EL PASO COUNTY STORMWATER MANAGEMENT PLAN CHECKLIST

EPC Project Number:

Revised: October 2021

**NOTES**

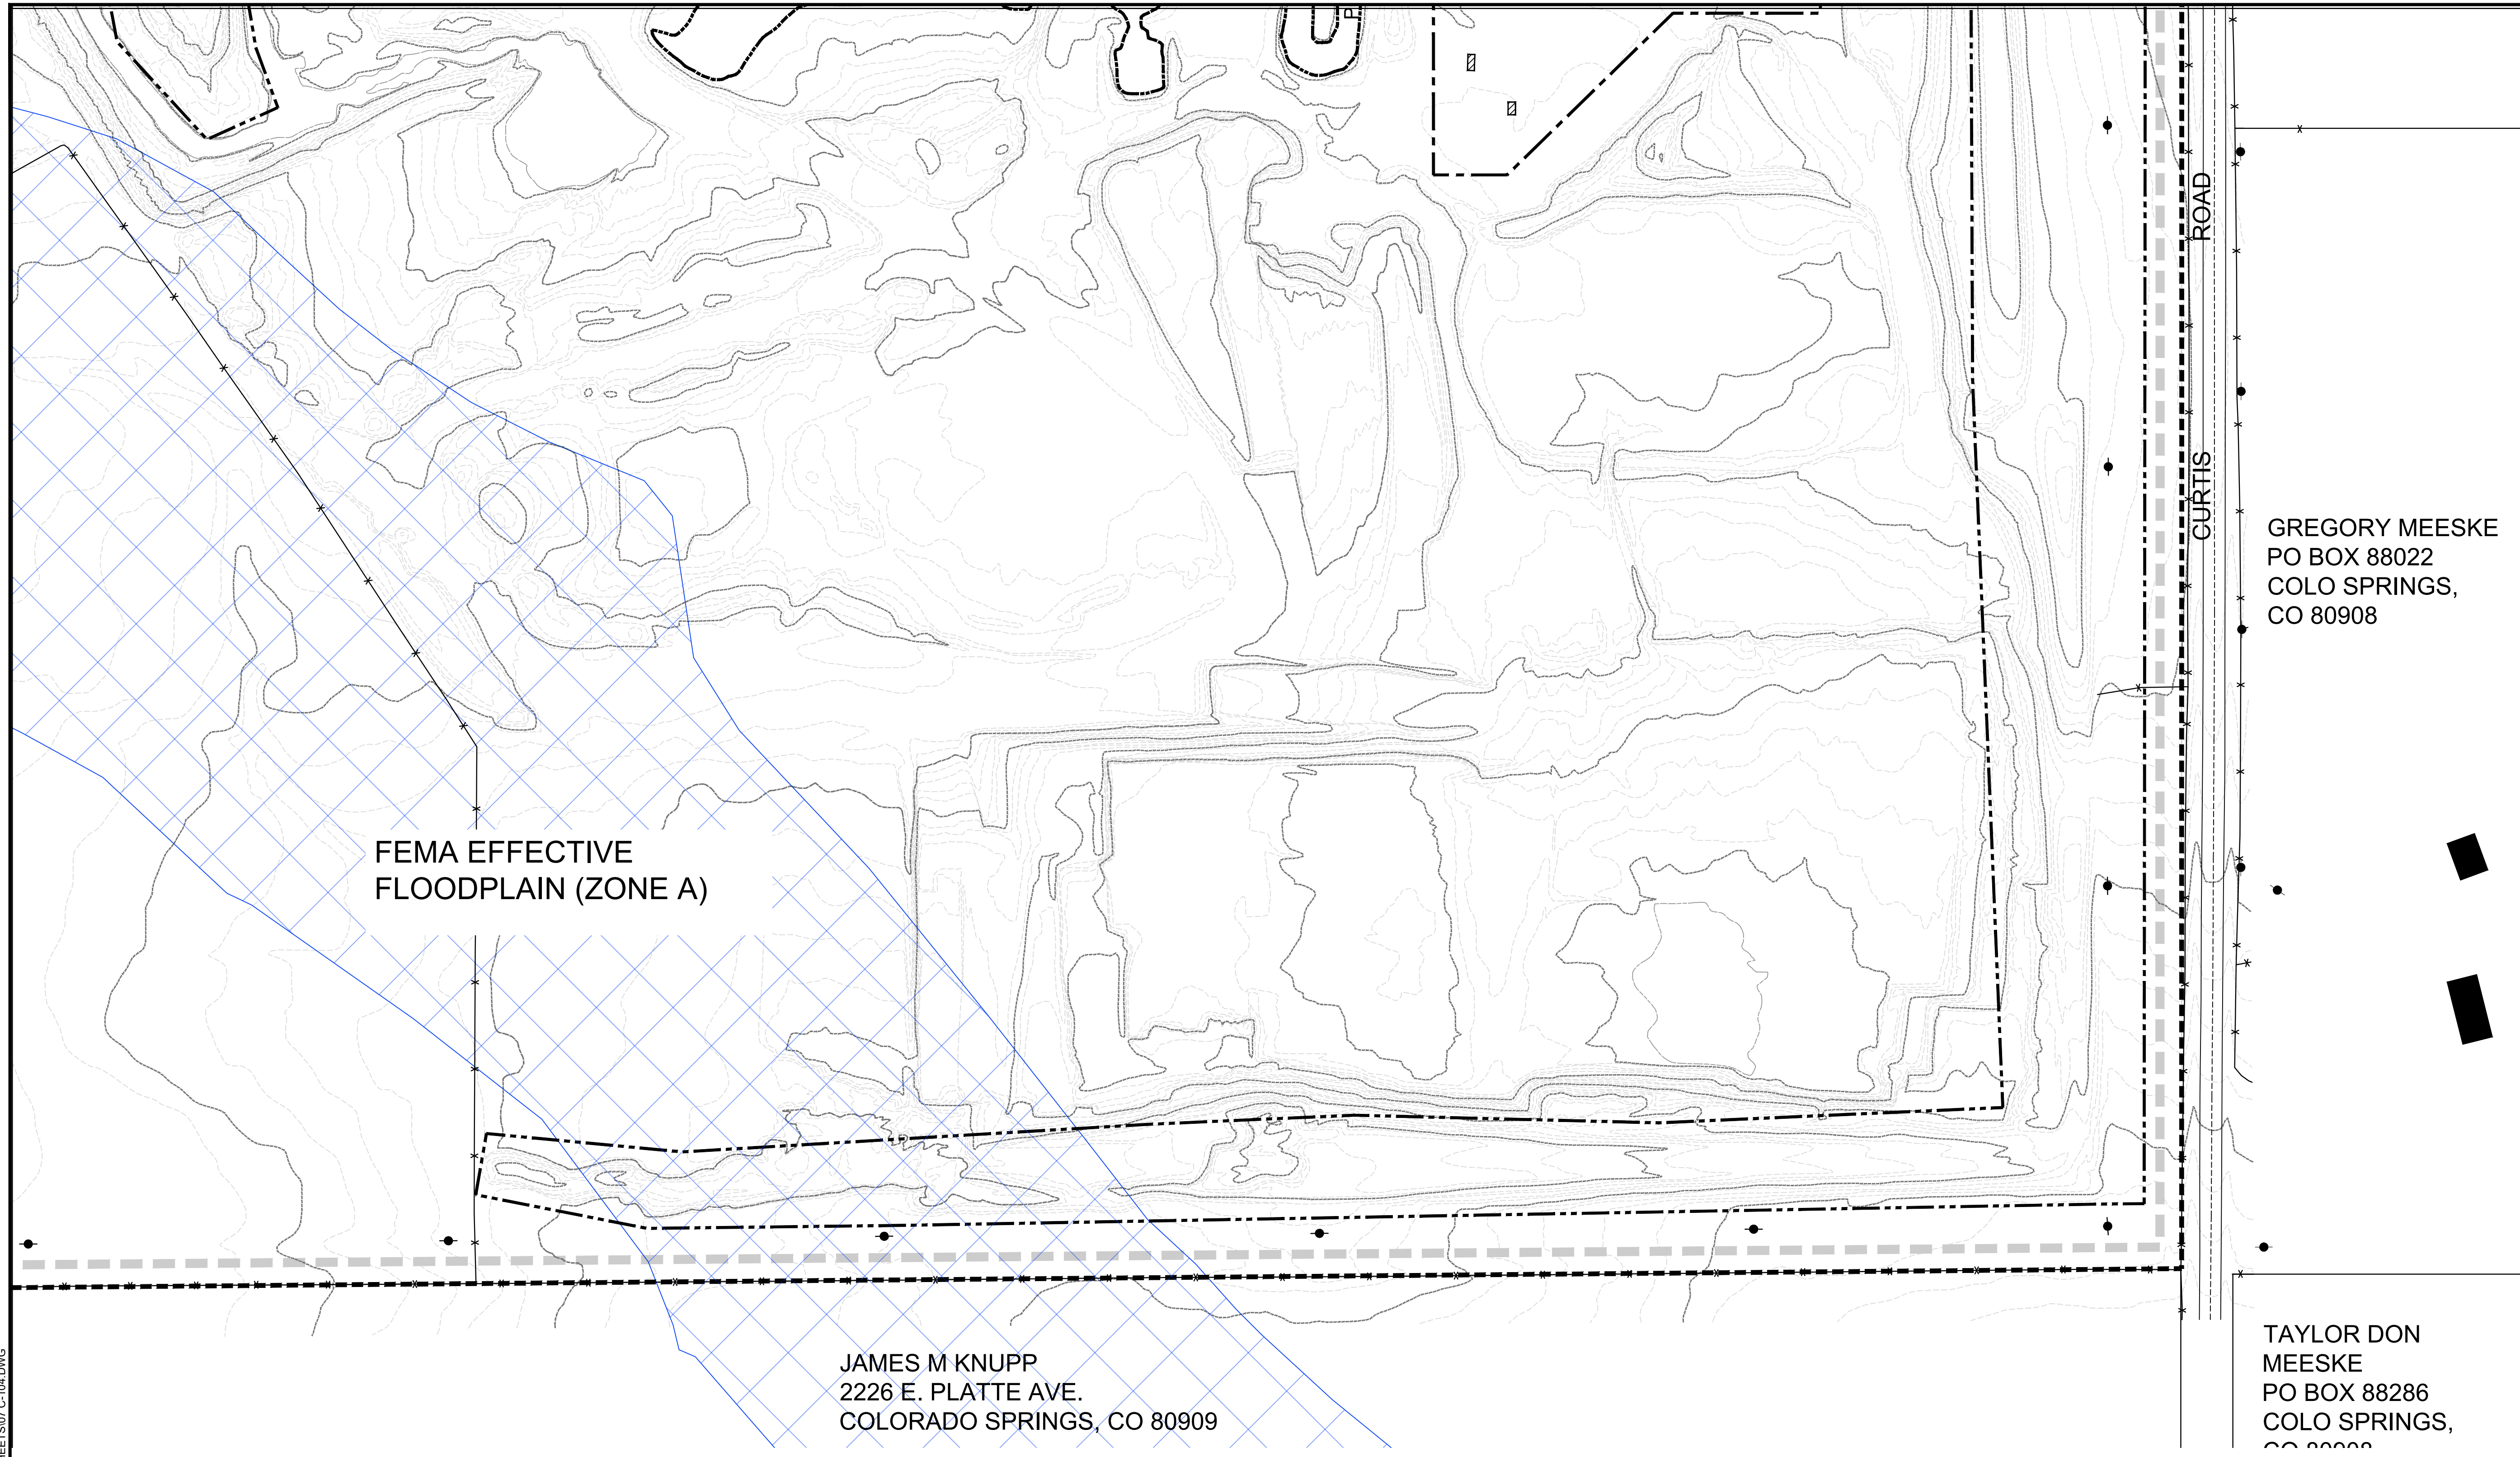
Applicant	EPC
17	SWMP Map to include:		
17a	construction site boundaries		X
17b	flow arrows to depict stormwater flow directions		X
17c	all areas of disturbance		X
17d	areas of cut and fill		X
17e	areas used for storage of building materials, soils (stockpiles) or wastes		✓
17f	location of any dedicated asphalt / concrete batch plants		✓
17g	location of all structural control measures		X
17h	location of all non-structural control measures		X
17i	springs, streams, wetlands and other surface waters, including areas that require maintenance of pre-existing vegetation within 50 feet of a receiving water		✓
18	Narrative description of all structural control measures to be used. Modifications to EPC standard control measures must meet or exceed County-approved details		✓
19	Description of all non-structural control measures to be used including seeding, mulching, protection of existing vegetation, site watering, sod placement, etc.		✓
